PL- Consultation- Tree officer response

Reference: **AW/238/25/T**

Proposal: Crown reduction to 1no. Norway maple, purple-leaved (T1) to leave a height of 8m and spread of 8m.

Location: 131 Manor Way, Aldwick, PO21 4HL

TI

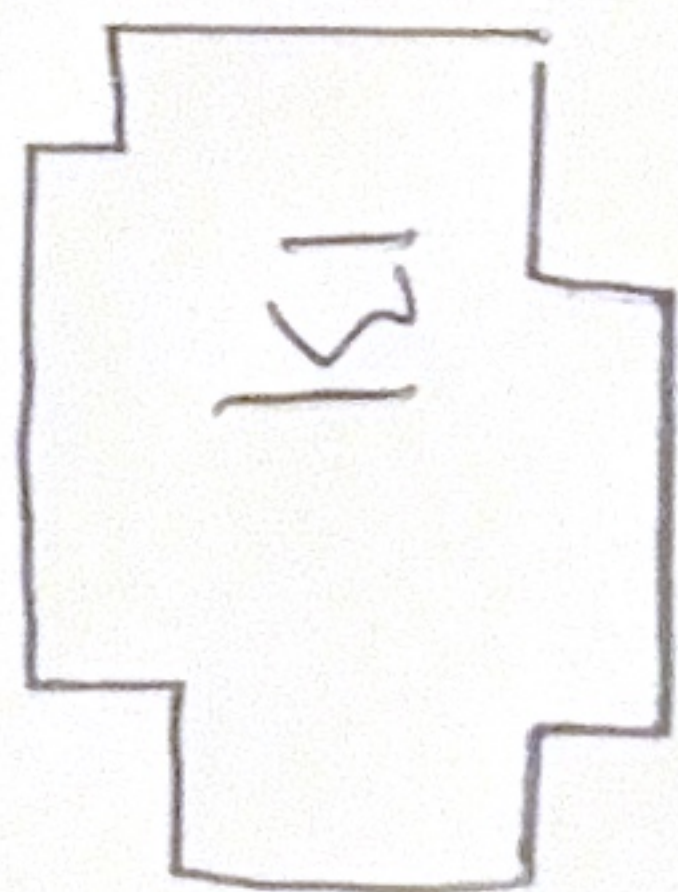
I am satisfied the work is justified and will not result in harm to the character or appearance of the conservation area.

I raise **No Objection** and see no reason to make a Tree Preservation Order.

Recommended INFORMATIVE: Hard pruning creates numerous and/or large wounds, incurring a physiological stress which may affect long-term health and vitality. The optimum time to prune maples is summer or winter (mid), as they are prone to bleeding.
